KIRKLEES METROPOLITAN COUNCIL INVESTMENT & REGENERATION SERVICE

DELEGATED DECISION TO DETERMINE PLANNING APPLICATIONS

Reference No:	2024/62/91970/W
Site Address:	Calgary, 5, Hebble Drive, Netherthong, Holmfirth, HD9 3XU
Description:	Erection of single storey side and rear extension with associated internal and external works
Recommending Officer:	Molly Storer

HOUSEHOLDER DELEGATED REPORT

title General arrangement as proposed
number 24023D-02-P03
scale 1:50, 1:100, 1:200
size A1

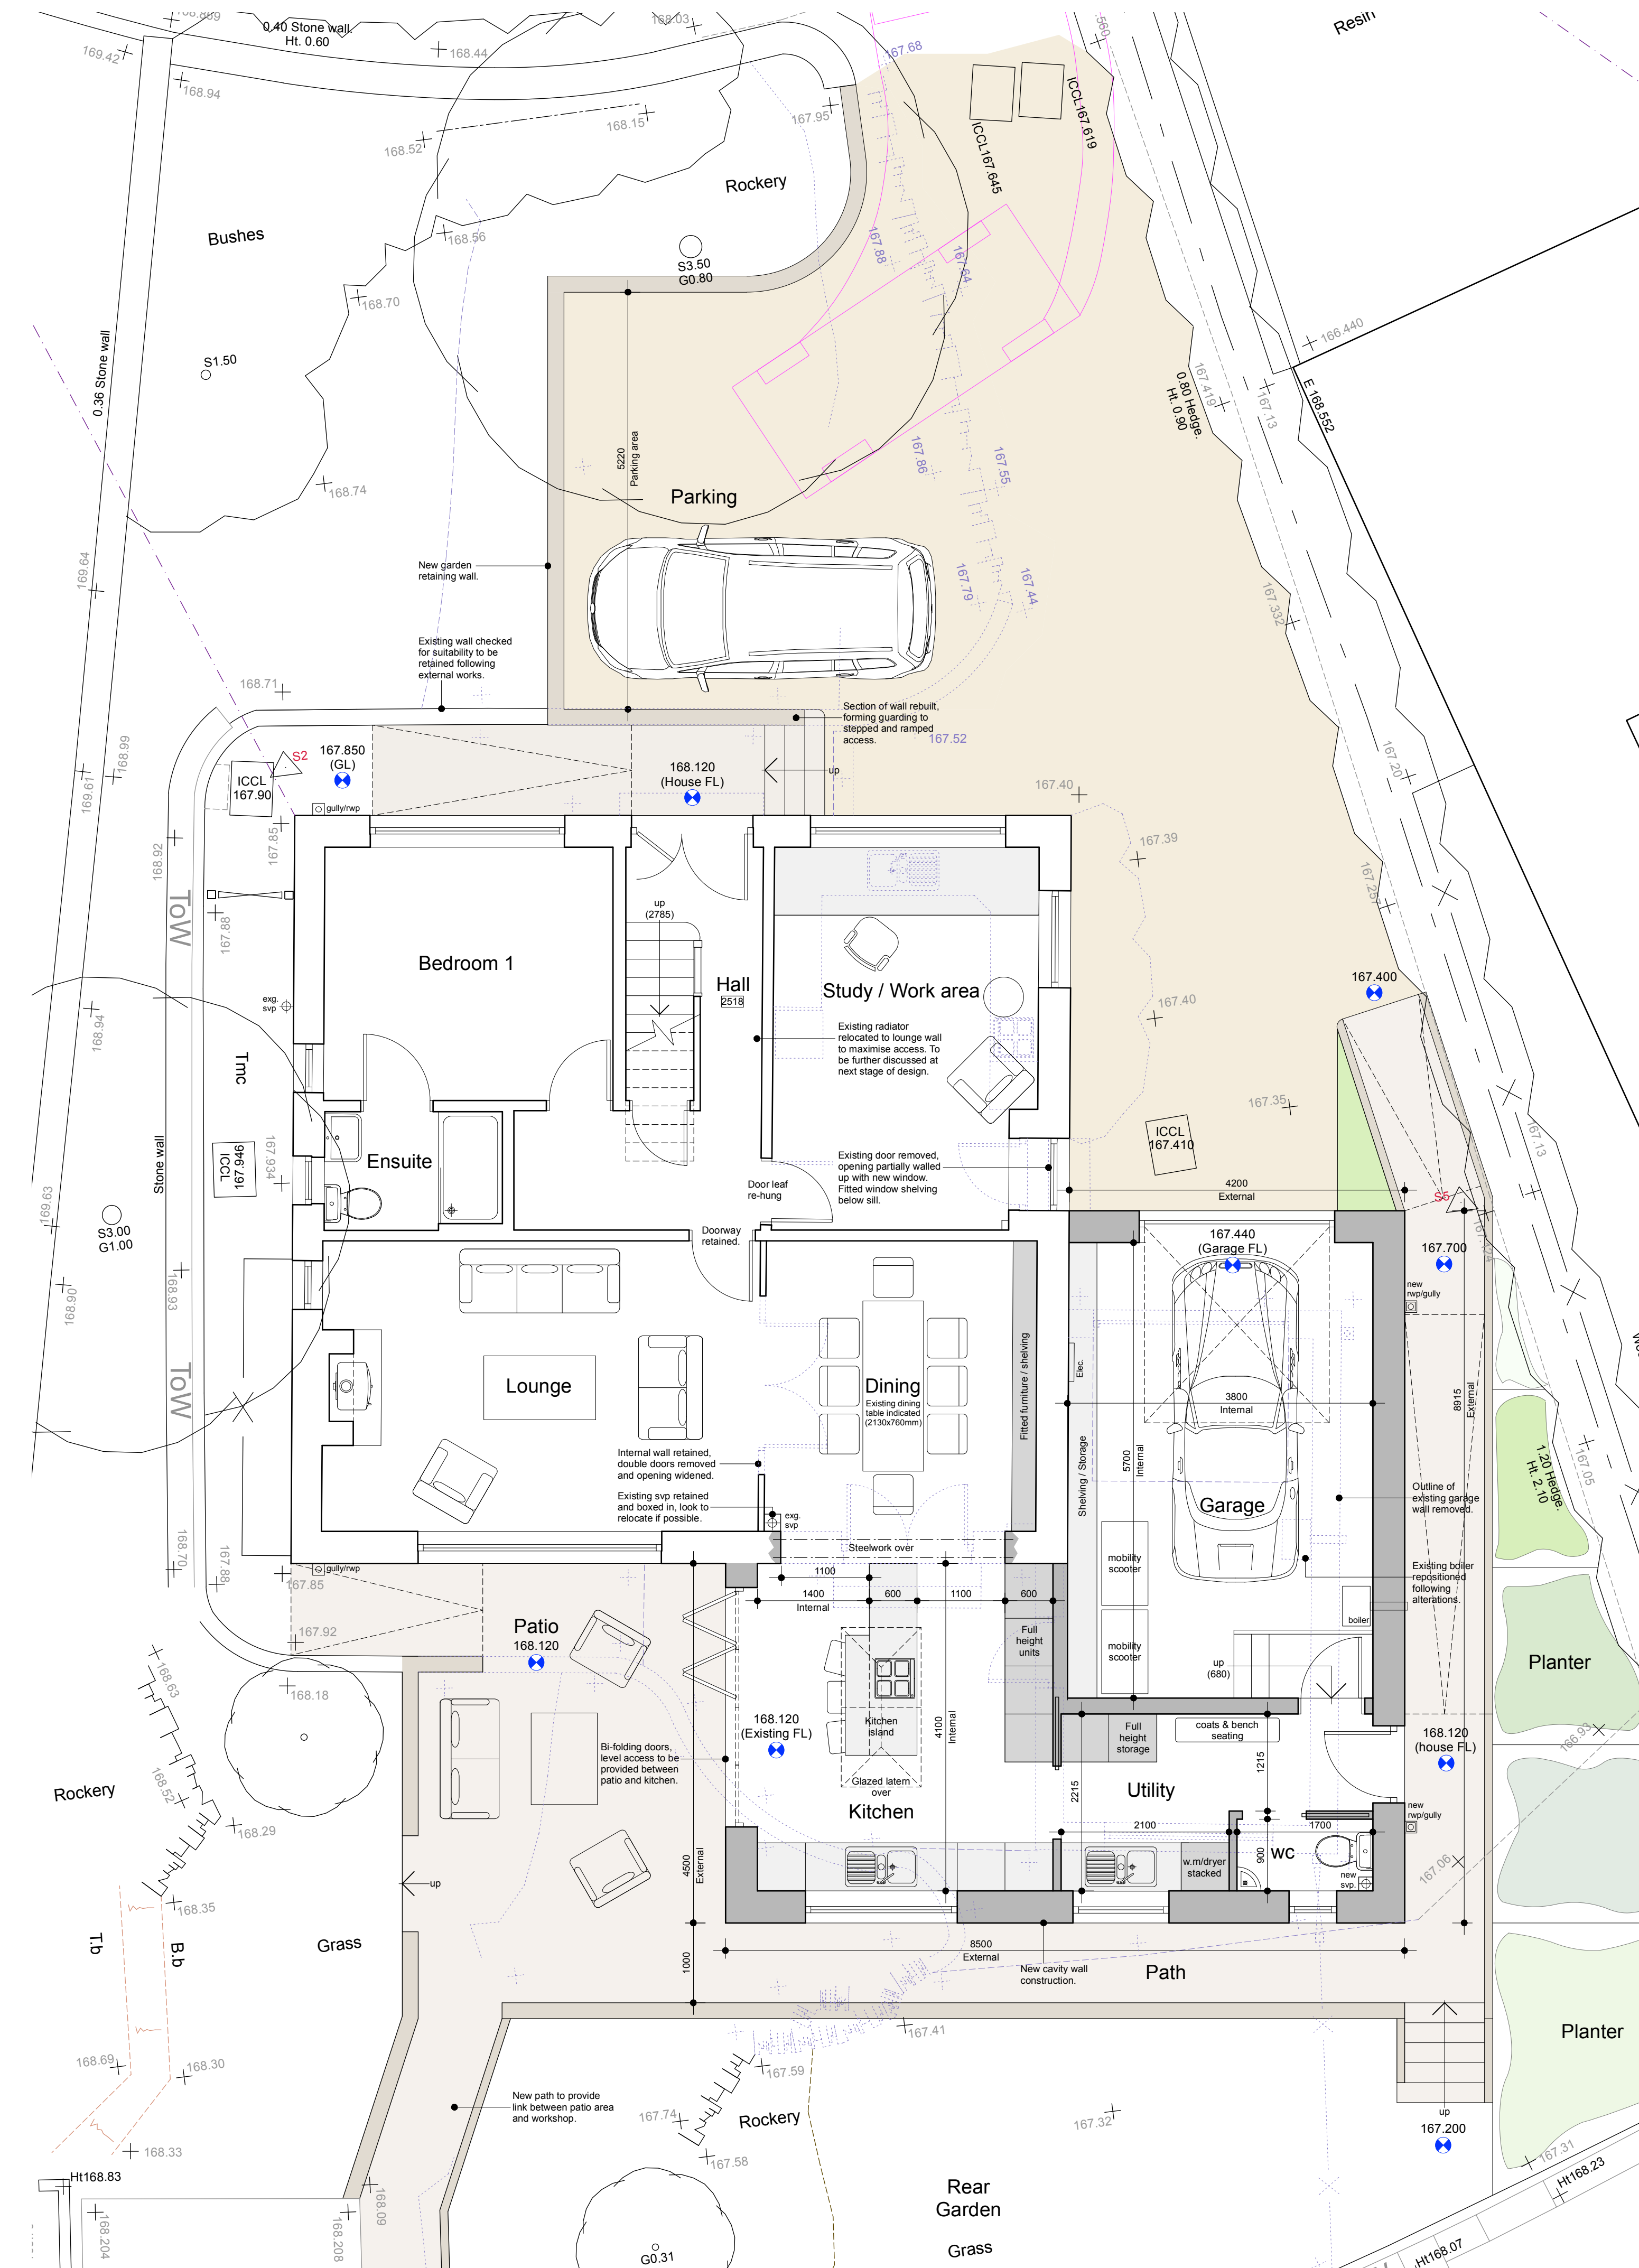
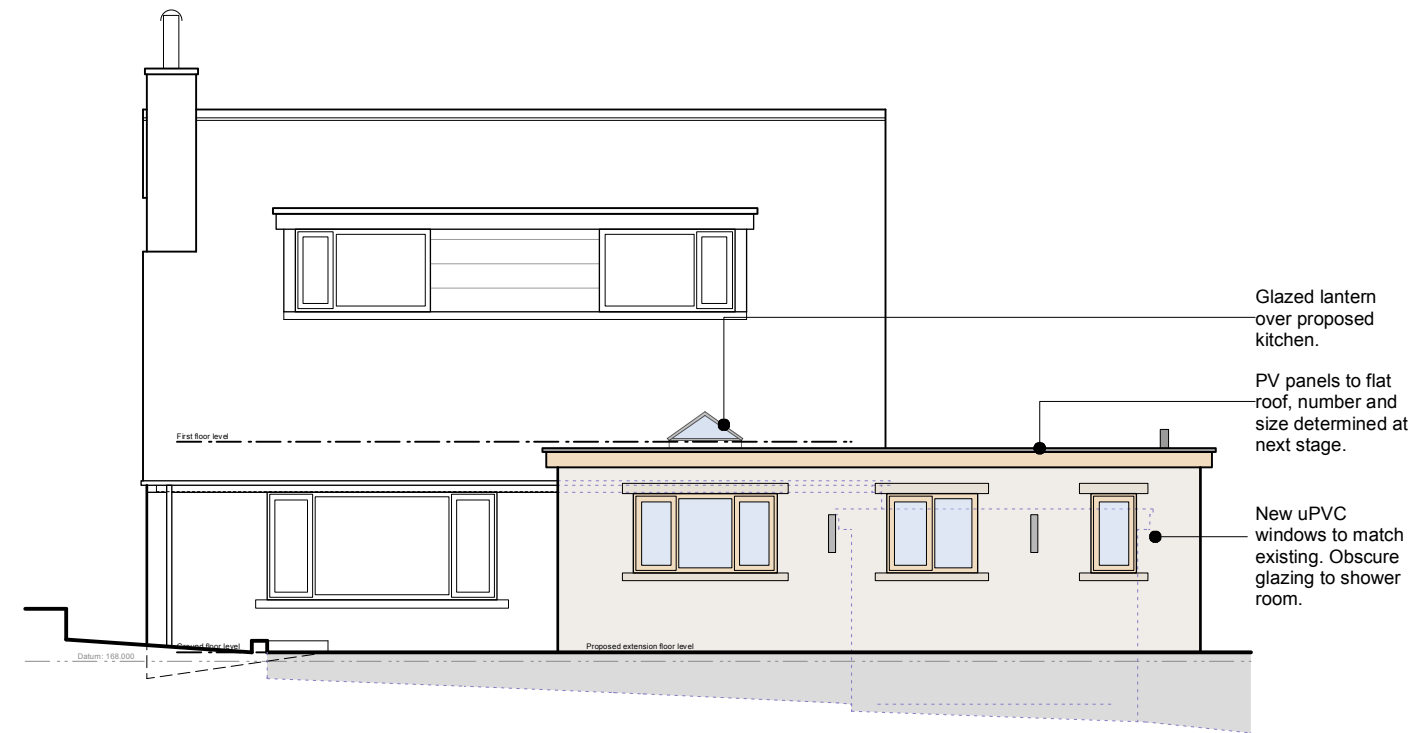
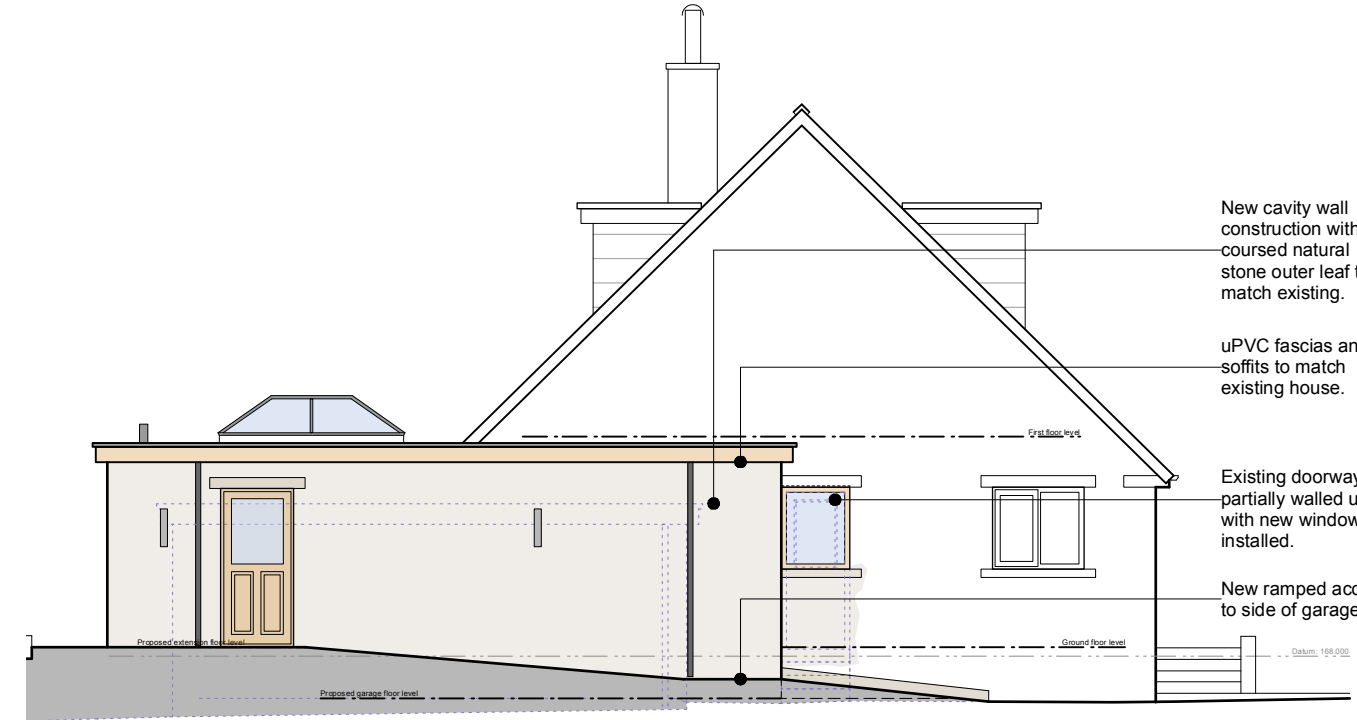
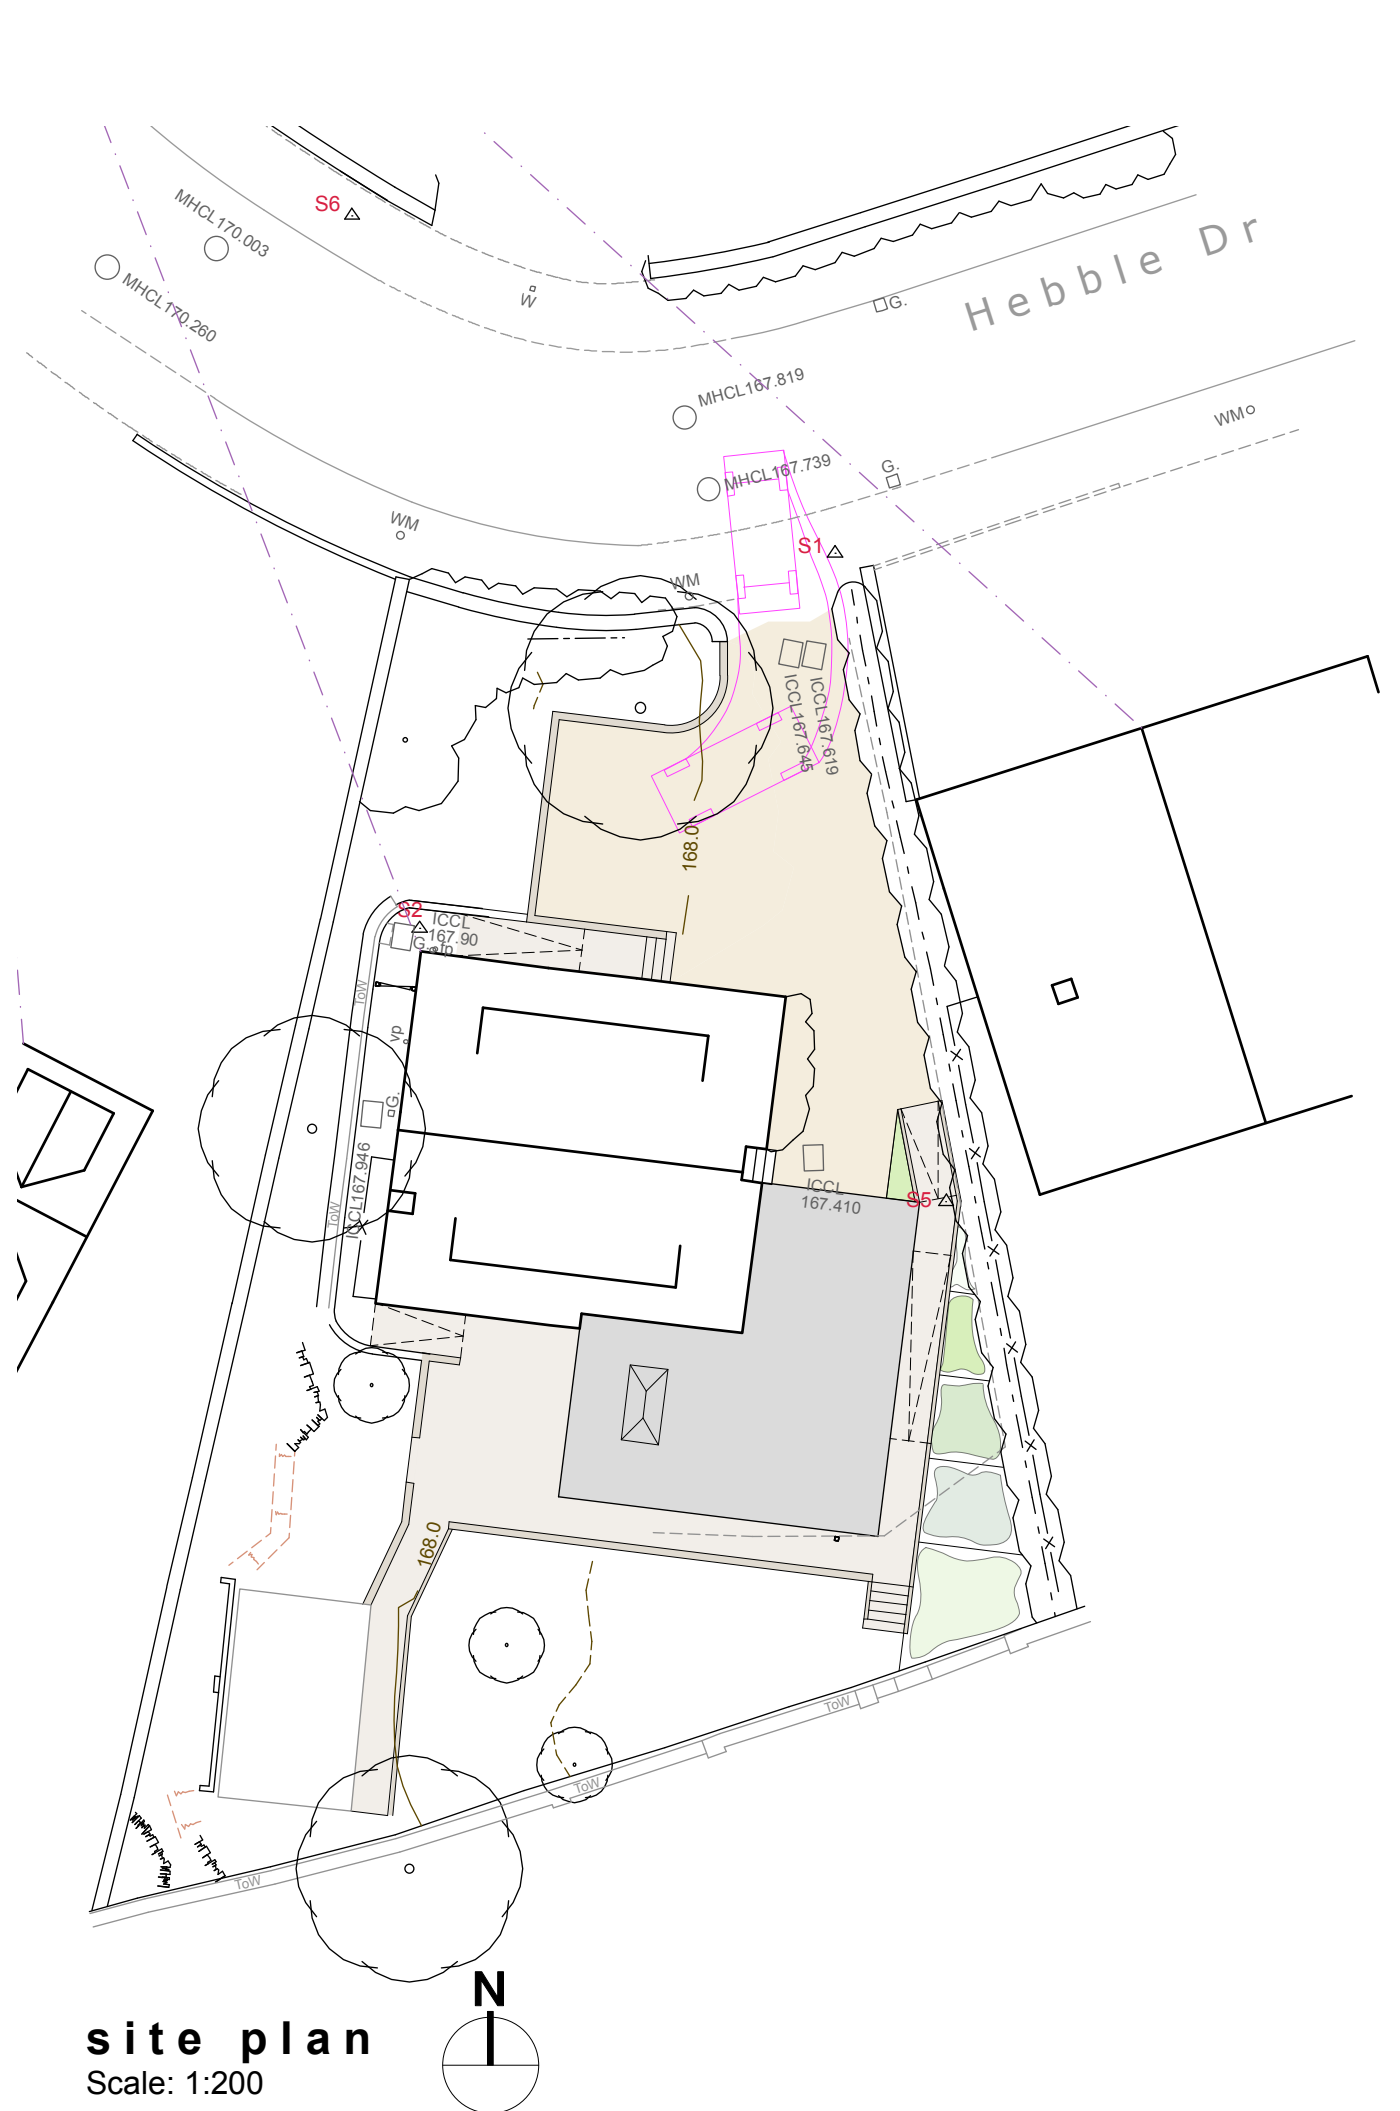
The single storey extension to the side would project 4.2m from the original side wall, extending 4.4m of the depth of the dwelling and 4.5m beyond the rear wall wrapping across the dwelling by 8.5m. The roof would be of an adjoining flat roof design connecting both elements.

Preserve a back garden of a reasonable size, with a general principle that at least half the garden area is retained	Yes – there is a large garden area to the rear more than half of this will be retained.	
Be set behind the original building, and not projecting beyond the sides		No – the extension projects 4.2m beyond the side elevation. However, this is justified as the original attached garage, located on a similar footprint to the side elevation, results in massing beyond the side boundary. The removal of this and the addition of the extension will not cause additional significant visual impact. Furthermore, this is considered acceptable in this case due to the front elevation of the extension being set back from the road by a large driveway and front garden.
Maintain external access to the rear garden	Yes – the plans show that external access will be maintained.	
Single storey rear extensions should:

will match the host property.	
Not normally cover more than half the total area around the original house (including previous extensions and outbuildings)	Yes – the extension will not cover more than half of the total area around the original house.	
Not exceed 4 metres in height		No – due to the topography of the site and the front of the site being at a lower ground level means that at the front of the property the extension will measure 3.4m from the ground level to the roof ridge. However, this is only the case for approximately 3.8m whereby after this towards the rear, and including the rear extension, the overall height will be 3m above ground level.
Not project out more than 3 metres from the rear wall of the original house for semidetached and terraces houses or by 4 metres for detached properties		No - the property is detached and the extension will project 4.5m from the rear. However, this is considered acceptable due to the existing garage projecting 3.6m beyond the rear wall of the original dwellinghouse. It is concluded that the additional metre will not cause any significant further harm.

Where they exceed 3m in length the eaves height should generally not exceed 2.5 meters		No – the extension will exceed 3m in height and due to the flat roof design the eaves height will be that of the overall height. However, in this instance due to neighbouring properties being situated at a

significant distance away and the overall height being limited it is considered that the additional 0.5m in height would not be reason for refusal in this case.
Retain a gap of at least 1 metre from a property boundary, such as a wall, fence or hedge	Yes – a distance of 1 metre will be retained to the property boundary.

Side extensions	<u>Yes - COMPLY</u>	<u>No - JUSTIFY</u>
Ensure reasonable levels of natural light to the habitable rooms in neighbouring properties	Yes – the extension would not be built up to the boundary of No.3 limiting the impacts. The gap will allow for reasonable levels of natural light into the side elevation of No.3.	
Positioning windows to minimise or avoid any potential overlook into neighbouring gardens	Yes- there are no windows within the east side elevation. There is only a single window which is not considered to significantly impact the neighbouring property.	
Single storey side extensions should:		
Not extend more than two thirds of the width of the original house	Yes – the extension will have a projection of 4.5m behind the side wall of the original house whereas the original width is 9.7m.

not exceed a height of 4 metres	Yes – maximum height of 3.4m.	
be set back at least 500mm from the original building line to allow for a visual break	Yes – set a significant distance behind the original building line.

• Policy 1 & 2 of the HVNDP • Chapter 12 of the NPPF	terms of height, scale and massing the extension would be subservient to the original house and the wider street scene.	
Facing materials and detailing	• KDP 9 of the SPD • Policy LP24 Design (d) (iii) of the KLP • Policy 1 & 2 of the HVNDP • Chapter 12 of the NPPF	The walls are proposed to be coursed stone to match the existing property. In the event that planning permission is approved, a condition is recommended to ensure the materials match those of the host property.	✓
Roof style	• KDP 1 and 2 of the SPD • Policy LP24 Design (a), (c) and (d) of the KLP • Policy 1 & 2 of the HVNDP • Chapter 12 of the NPPF	Flat roof design to match that of other side extension within the street scene.	✓
Window proportions	• KDP 1 and 2 of the SPD • Policy LP24 Design (a), (c) and (d) of the KLP • Policy 1 & 2 of the HVNDP • Chapter 12 of the NPPF	There will be a garage door located within the front (north) elevation and a single door located within the east side elevation. Within the rear elevation there will be three windows and a bifolding door within the west side elevation.	✓

3. Notwithstanding the plans submitted the external walls and roofing materials of the development hereby approved shall in all respects match those used in the construction of the existing building and be retained thereafter.
